DELEGATED DECISION TO DETERMINE PLANNING APPLICATIONS

Reference No:	2025/62/92865/W
Site Address:	77, Grasmere Road, Gledholt, Huddersfield, HD1 4LJ
Description:	Erection of single storey rear extension
Recommending Officer:	Morgan Braithwaite

OFFICER REPORT

DRAWING TITLE
PROPOSED PLANS AND ELEVATIONS

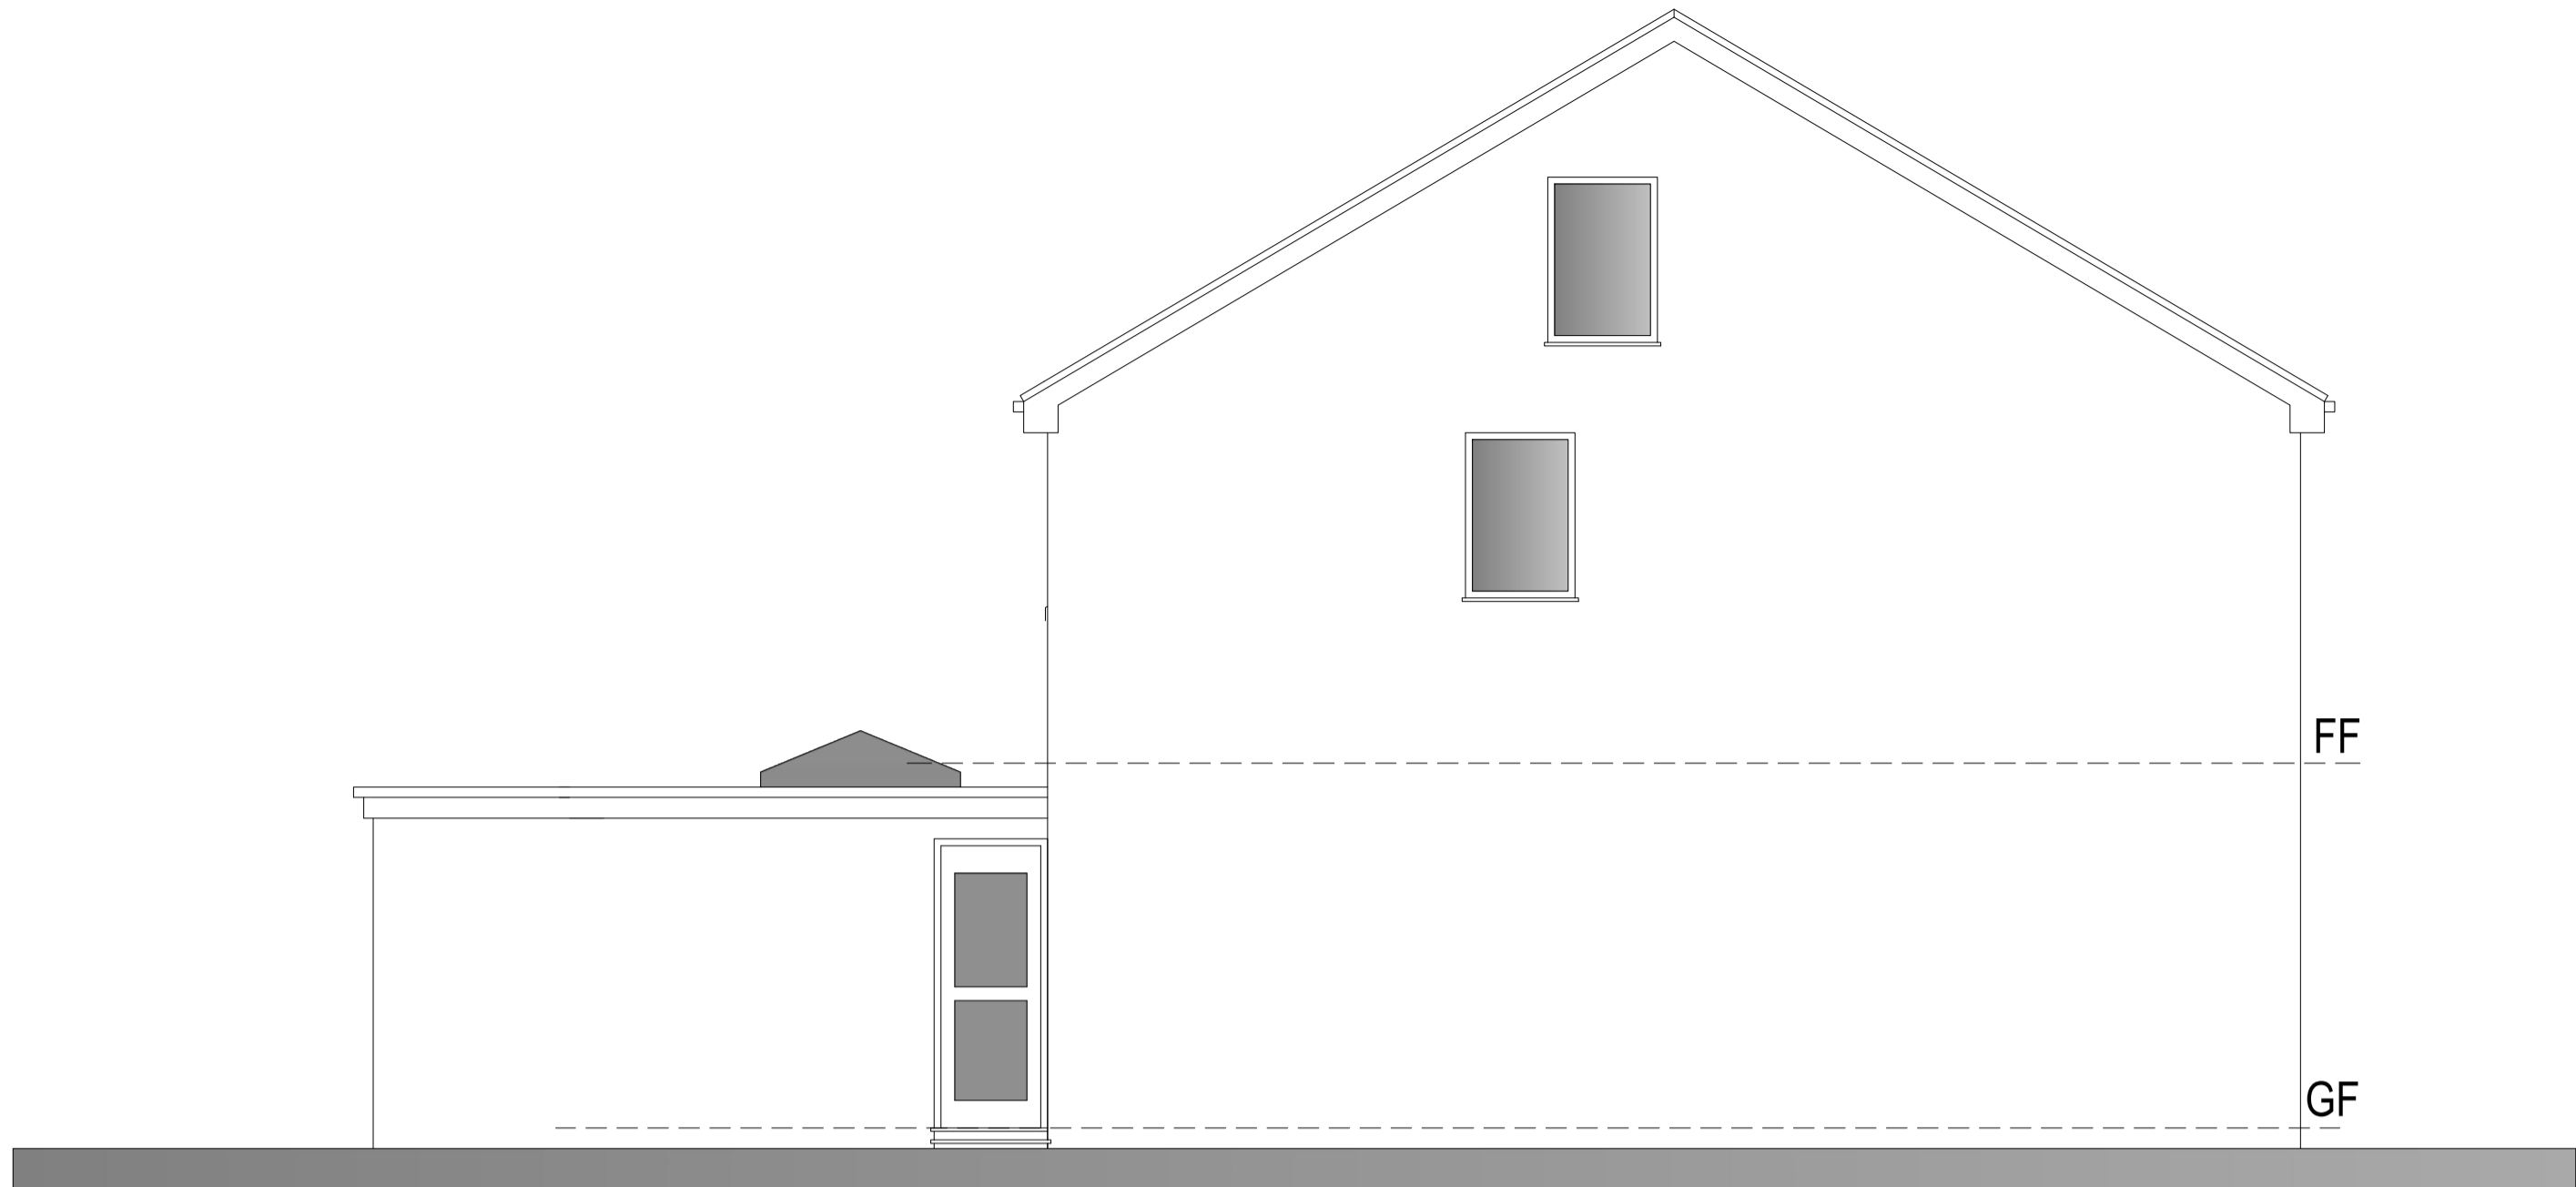
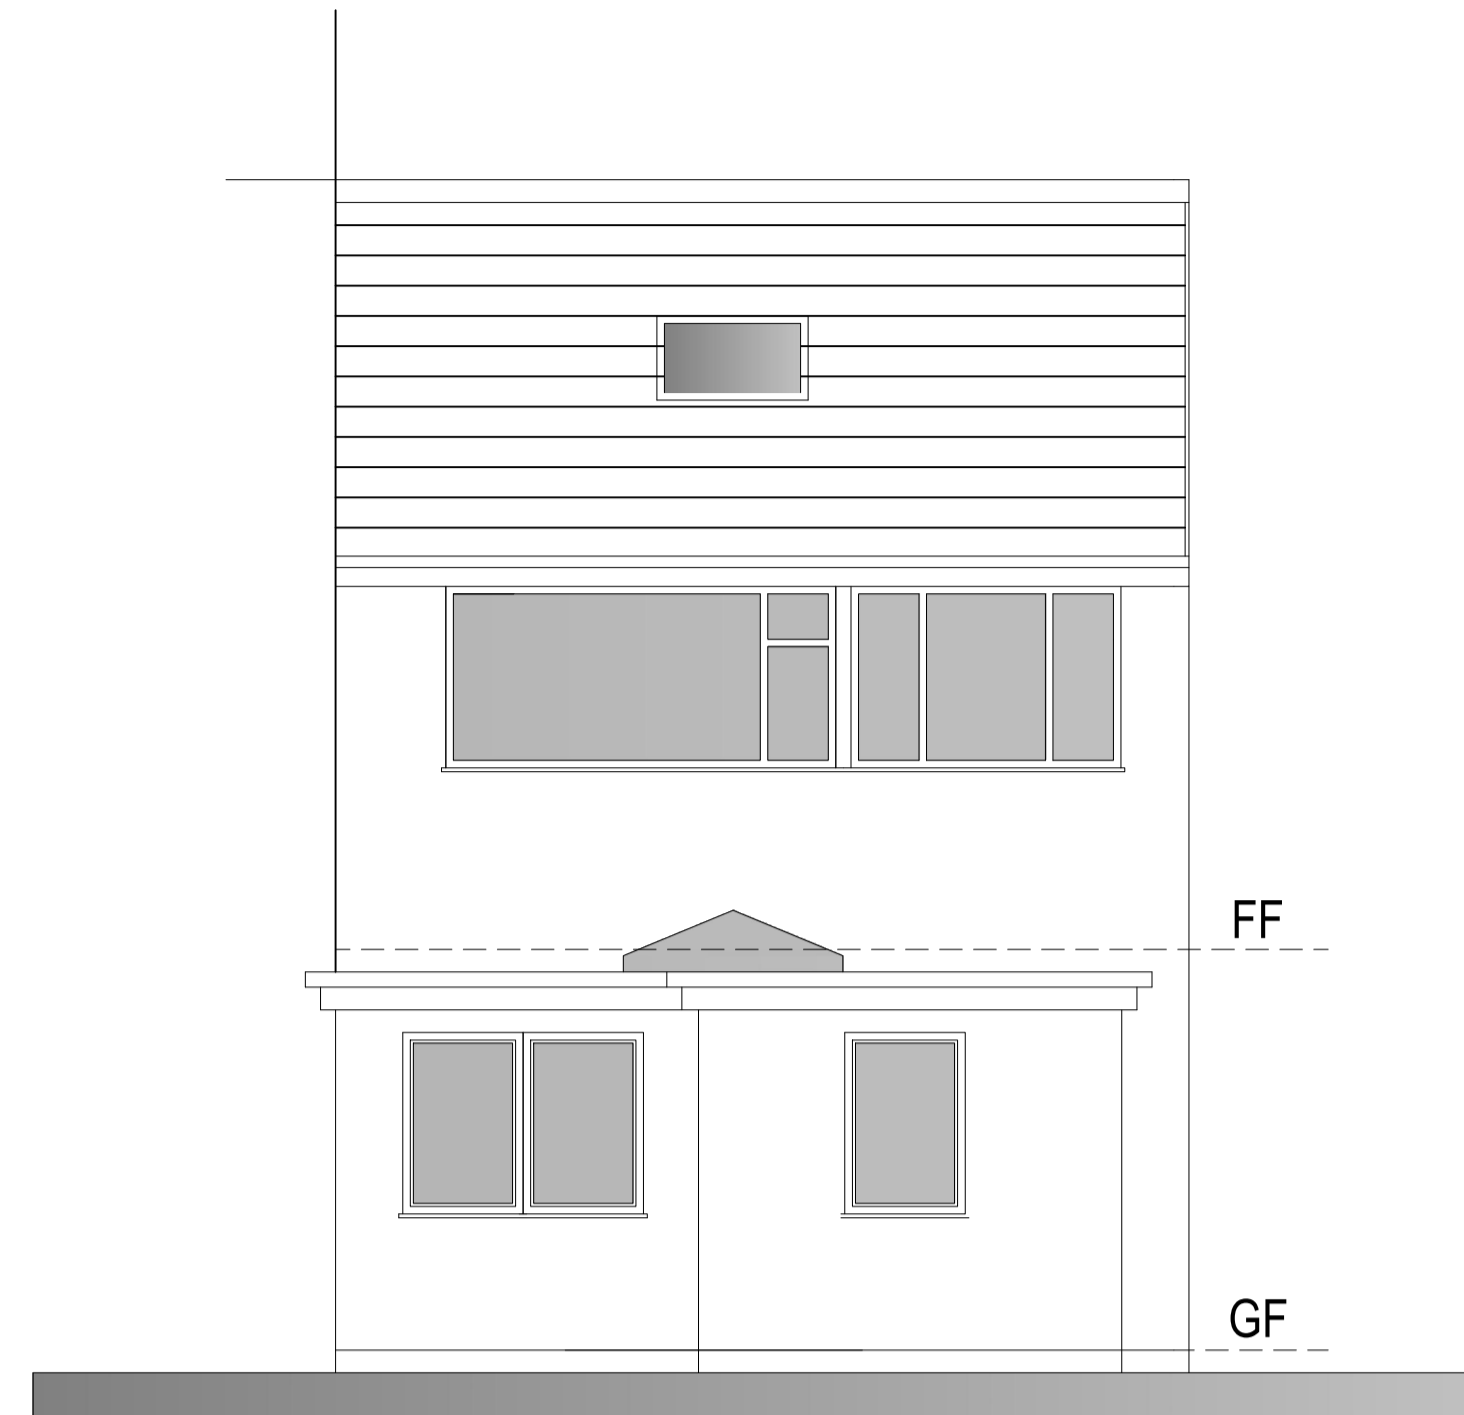
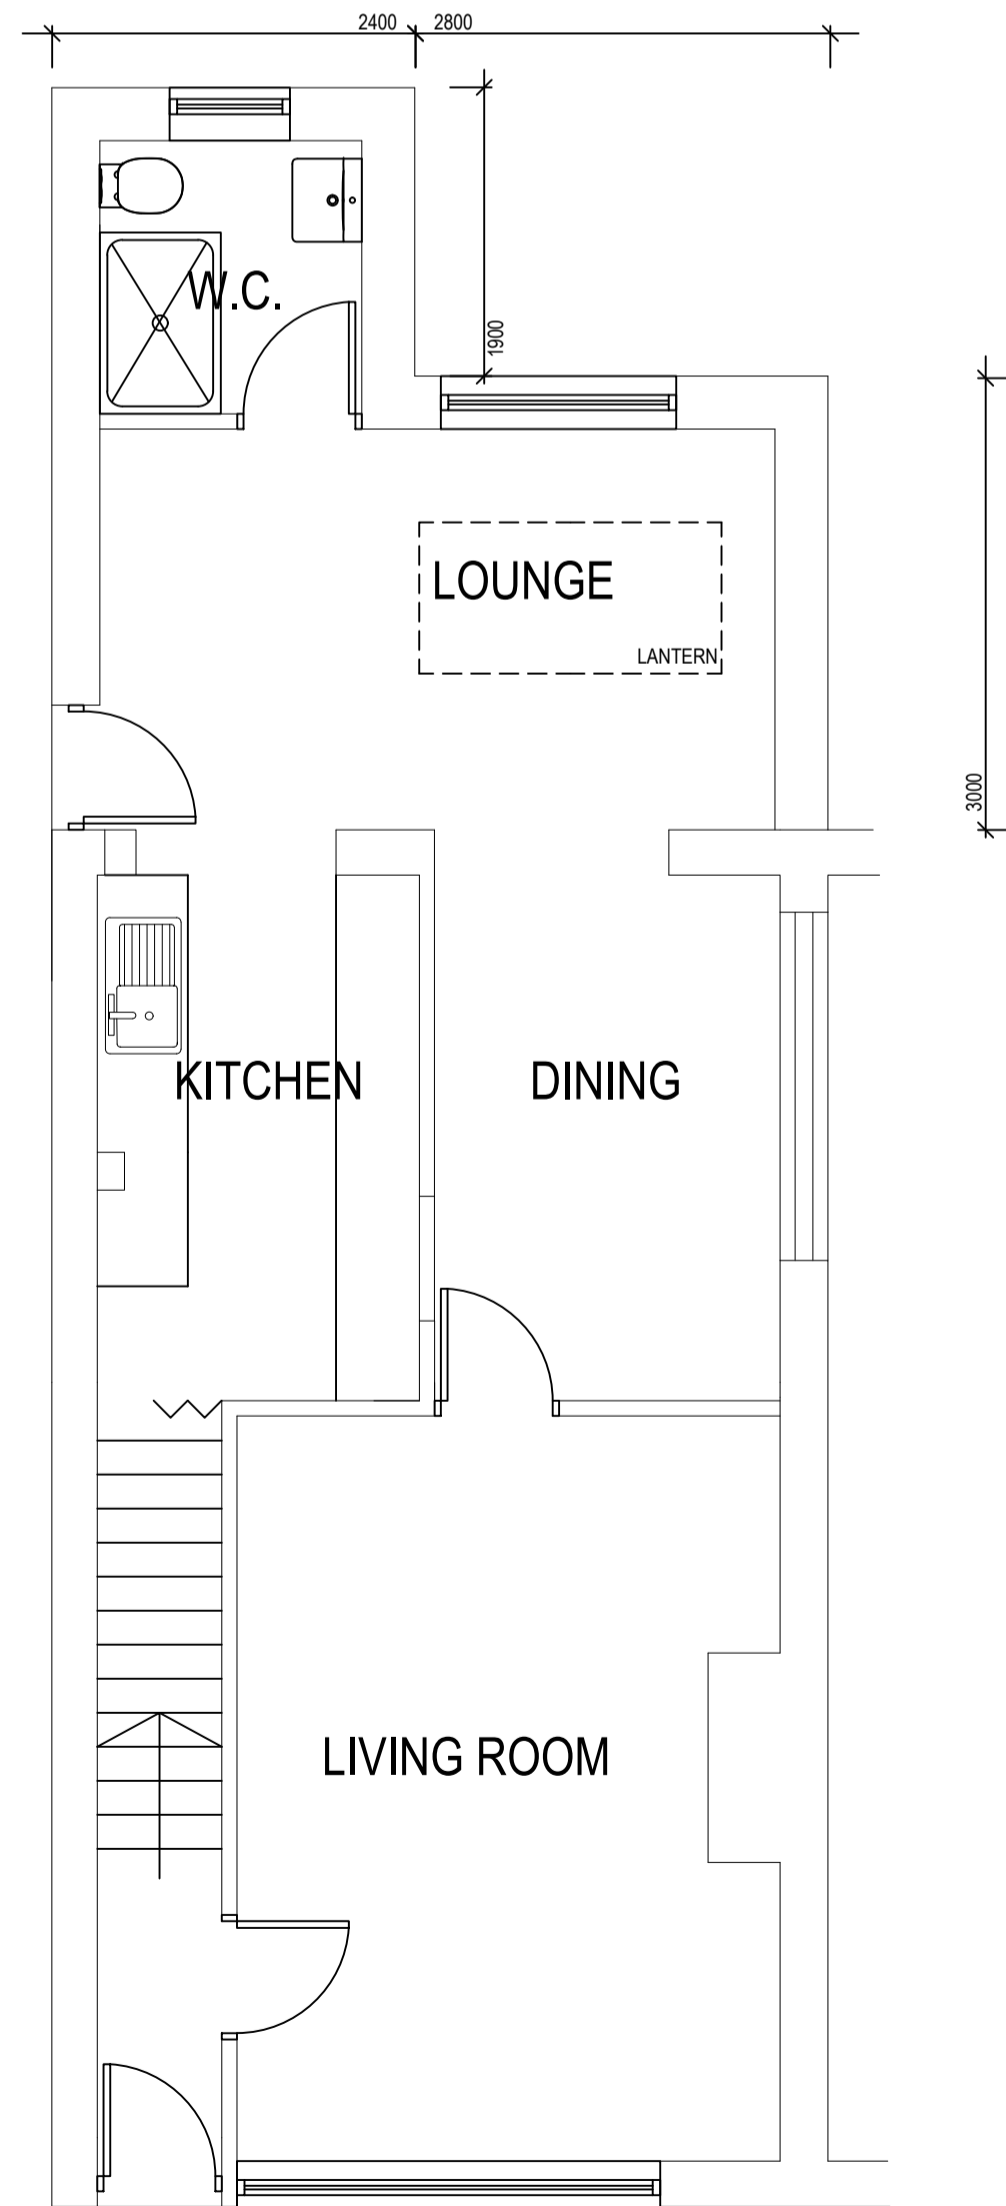
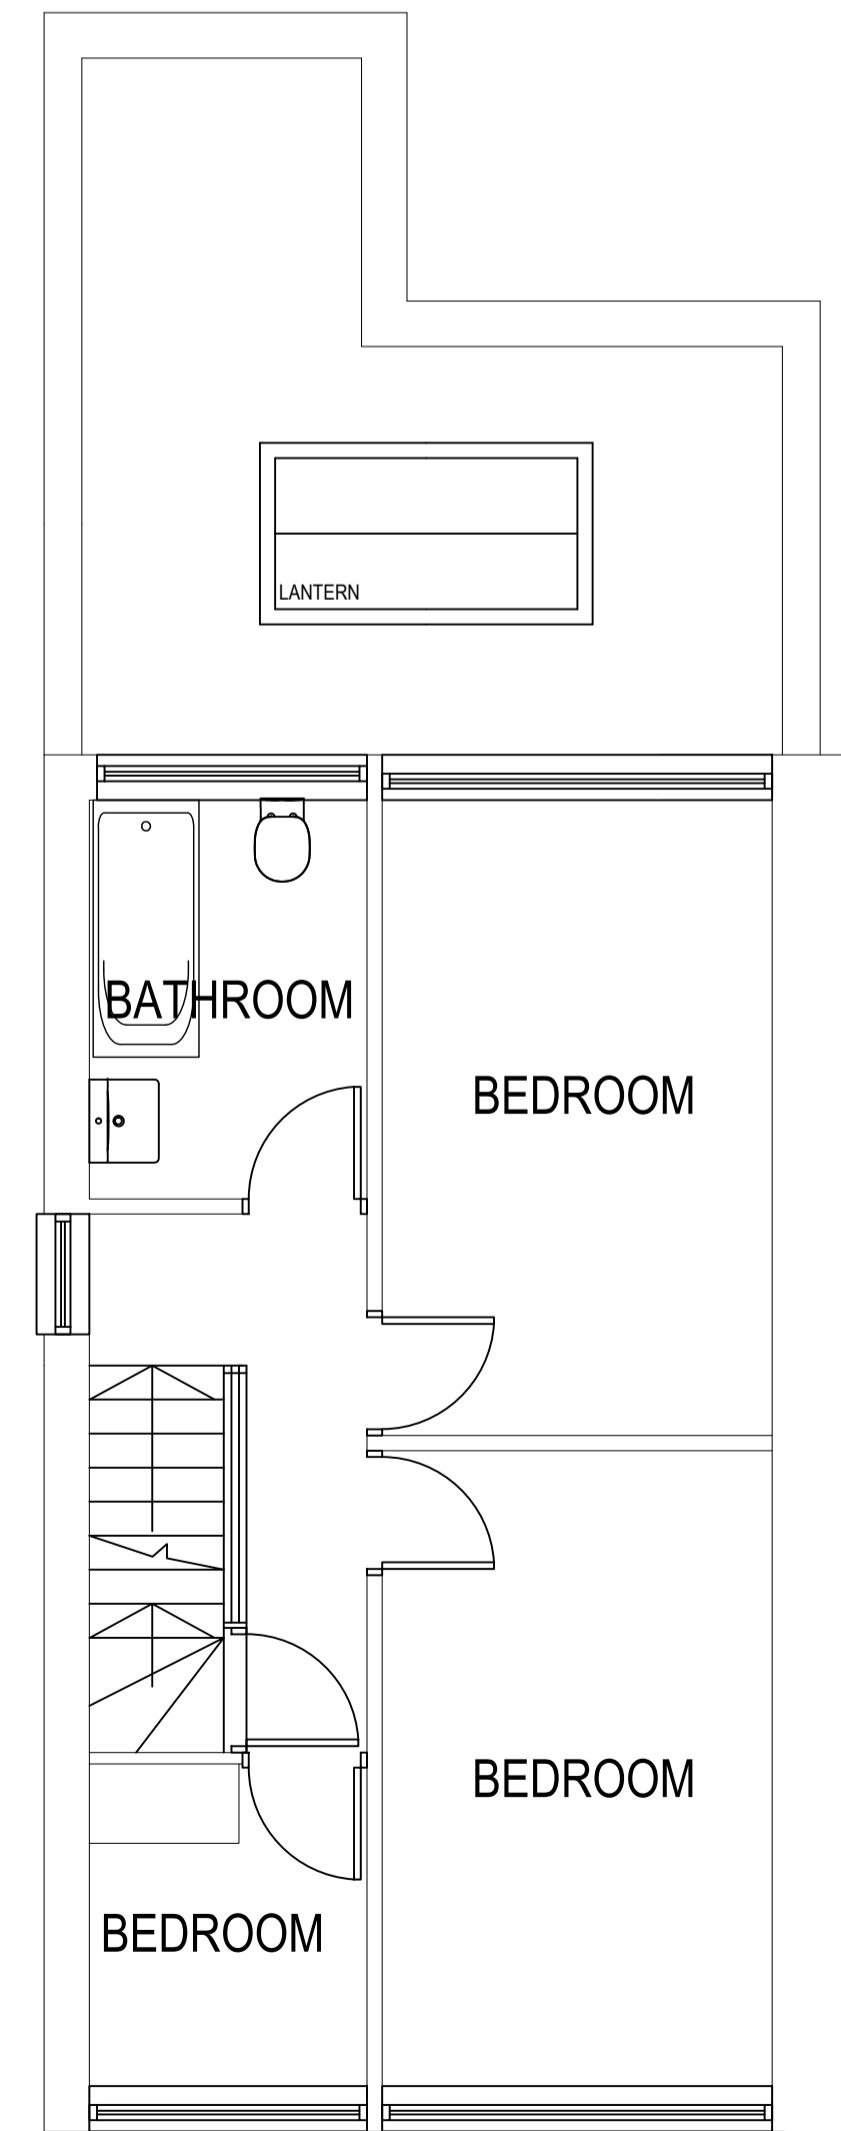
It was requested that amended plans be submitted indicating that the section along the shard boundary be a projection of 3m with the element which projects 4.9m 'switched' to the other side of the development and sited adjacent to the driveway of the property. Amended plans were submitted and the proposal is progressed on this basis.

No.79 is the adjoining dwelling to the application property. It is also noted that no.79 is owned by the applicant also. The proposal is for a single storey, flat roof extension which is to be constructed of materials matching that of the existing dwelling. Initial plans indicated that the proposal was to project 4m beyond the rear wall of the existing property, along with an additional 1.9m projection which would span 2.4m. This 1.9m element was to be constructed up to the boundary with no.79. It was requested that plans be submitted, showing this element to the north of the site, be re sited away from this boundary. It is further noted that the geographical orientation of the site lends itself to mitigating any impacts. The proposed works are to be located to the rear (east) of the application site and to the north of no.79. As such, any effects of overlooking, overshadowing/loss of light or overbearing impacts would be mitigated.

In summary, the revised scheme is considered to have suitably addressed the concerns raised in relation to the amenity of occupiers of the adjoining property and the proposal is concluded to have no adverse impact upon the residential amenity of adjacent occupiers and would accord with Policy LP24 of the KLP and the Key Design Principles of the House Extensions and Alterations SPD.
